Cc: Kate Giddings
Subject: WA/23/19/DOC

From: Kate Giddings
Sent: 08 May 2019 15:43
To: Charlotte Easton
Cc: Planning.Responses; Anna Appleton
Subject: WA/23/19/DOC - Fairmead Farm Land, Binsted Lane, Arundel, BN18 0LQ

RA / 674 / 100 D

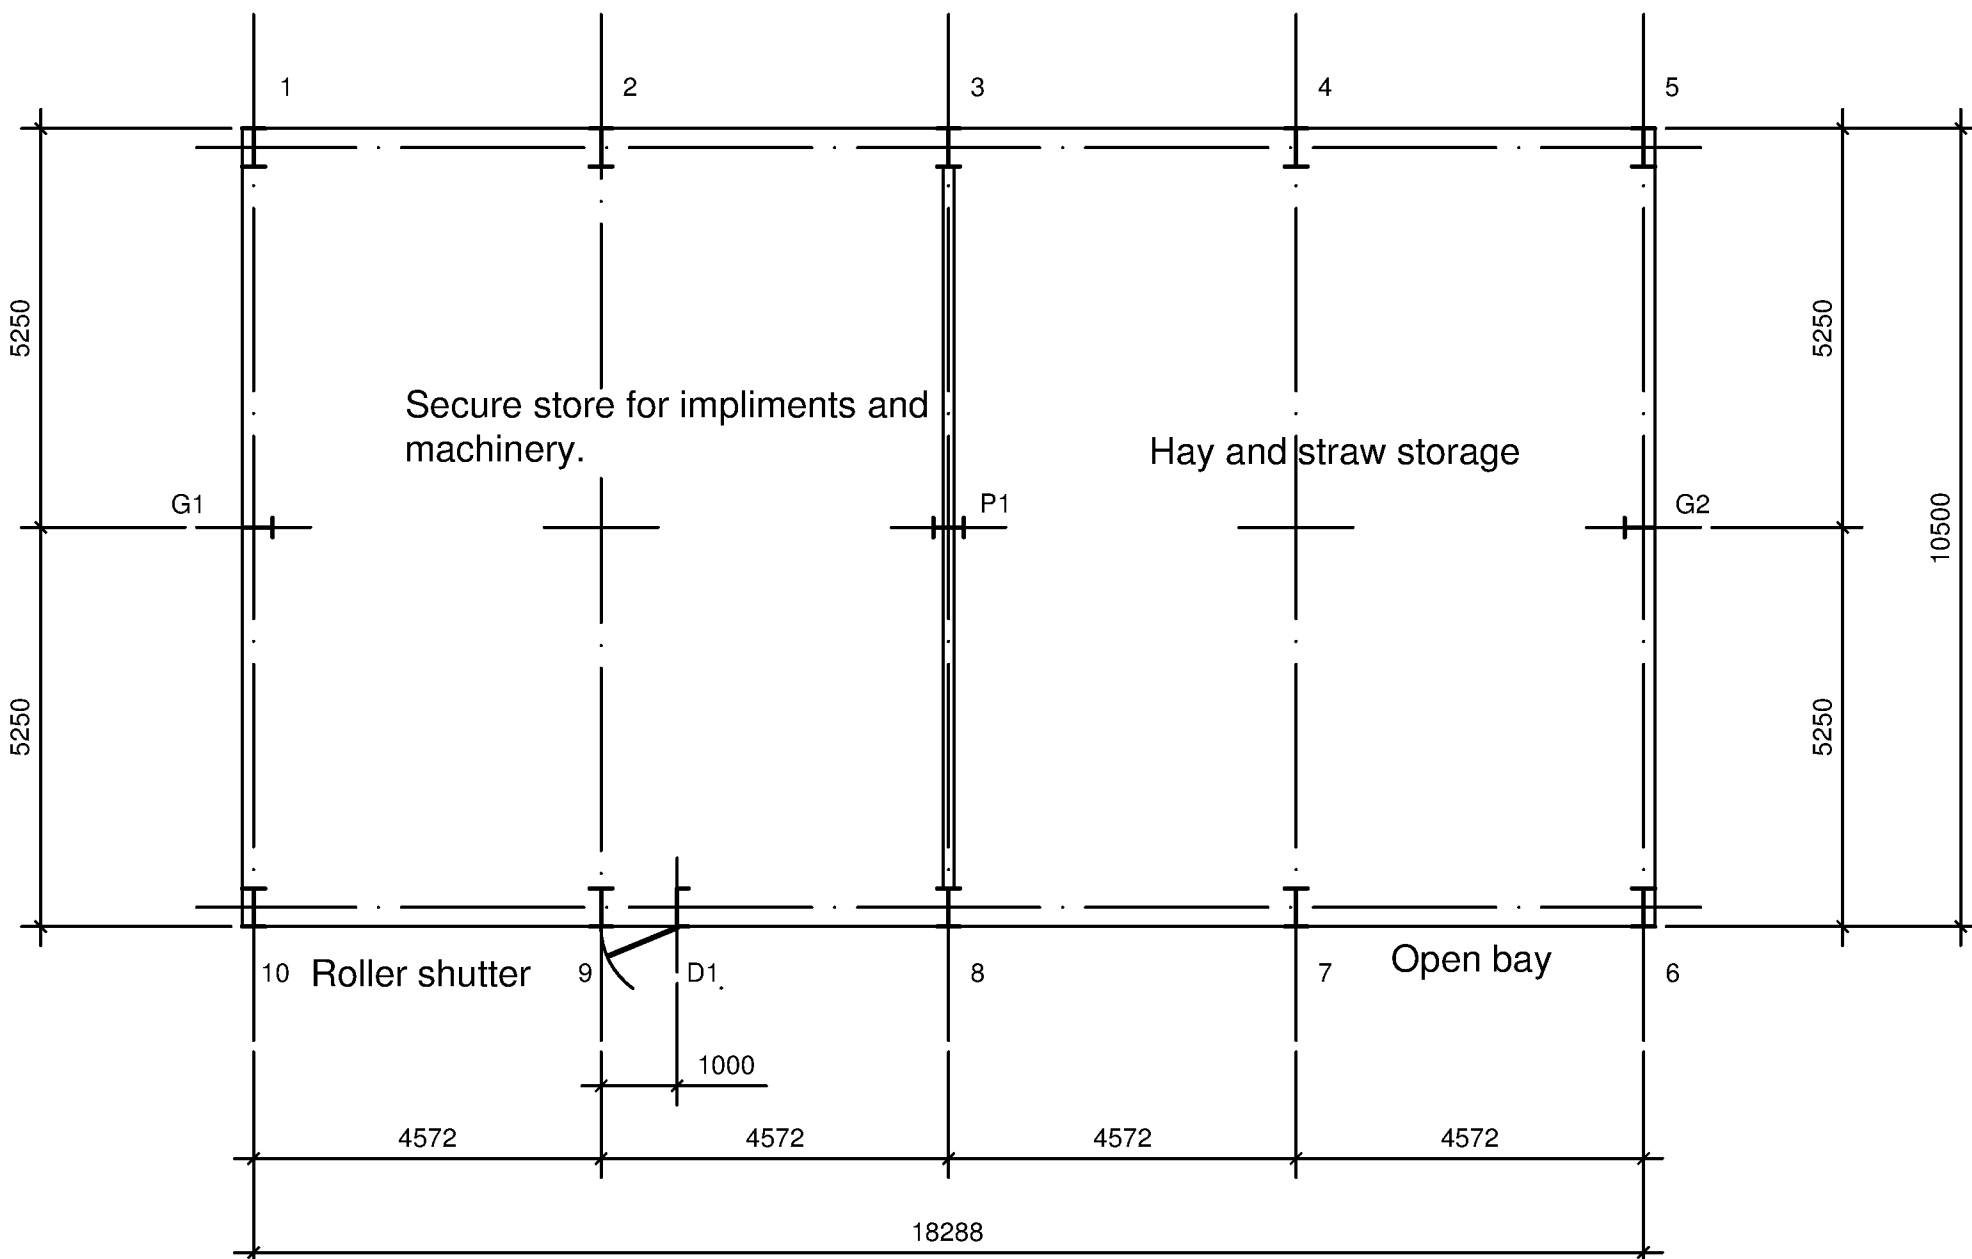
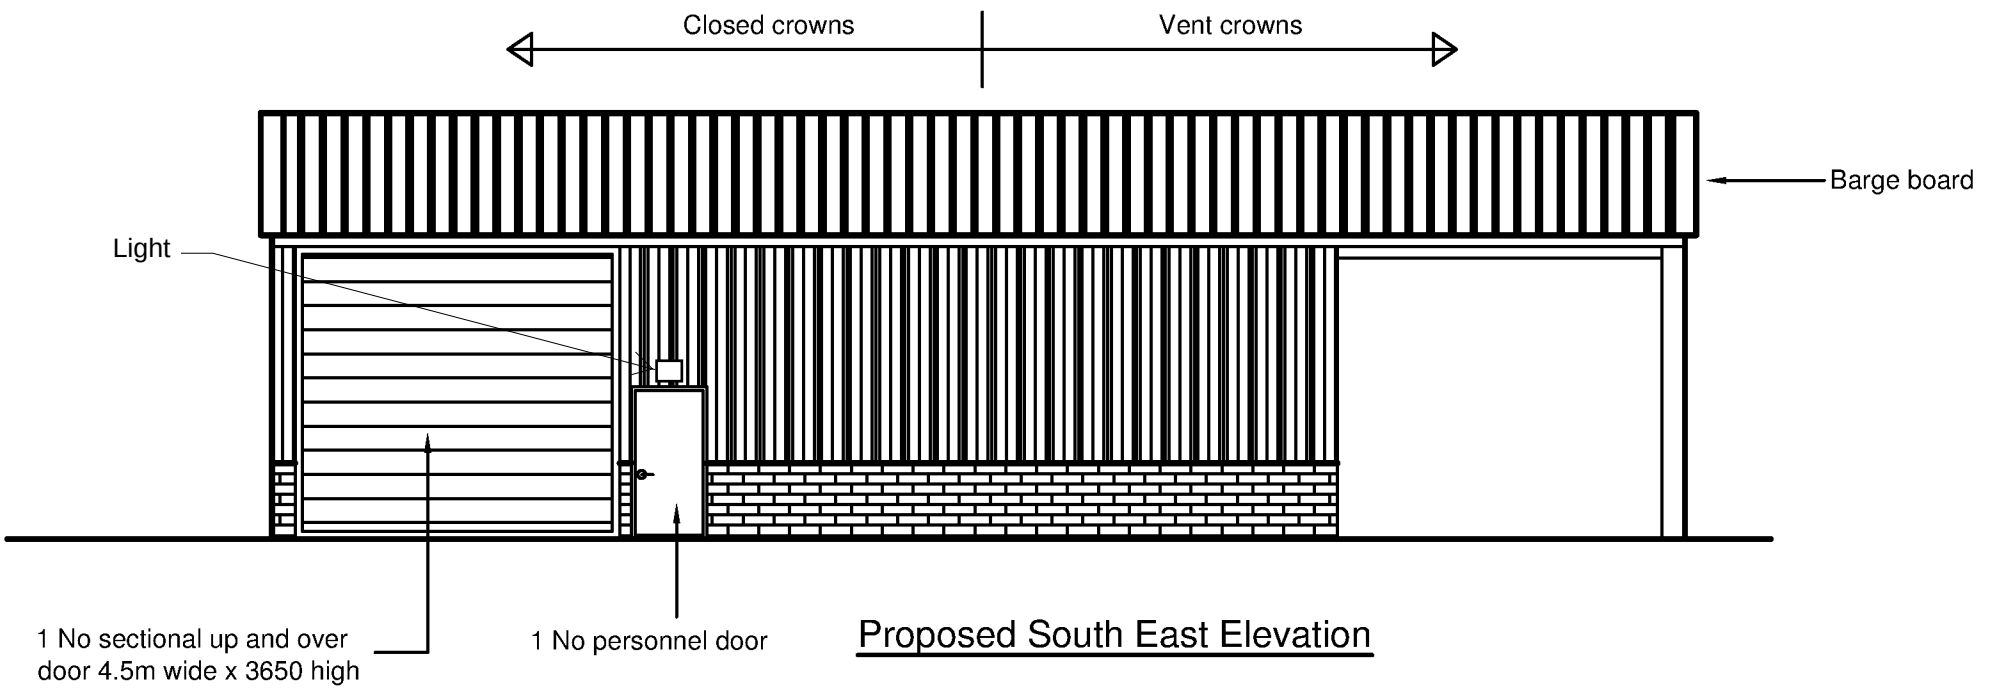
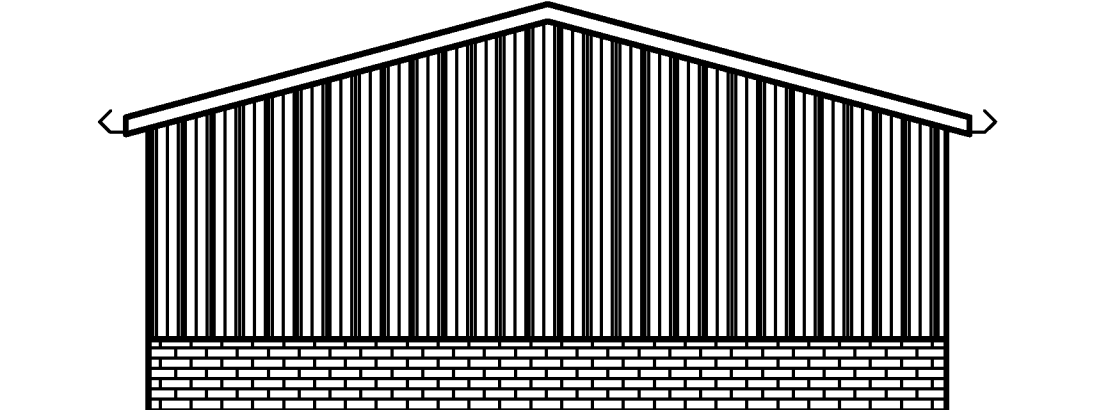
In relation to the above, the document supplied is not sufficient for this department to recommend discharge of condition 6 – external lighting.

For clarity, the condition requires details on the type of appliance, the height and position of fitting, illumination levels and light spillage. There should also be details regarding the potential impact to bats, however this is not something which can be assessed by this Department.
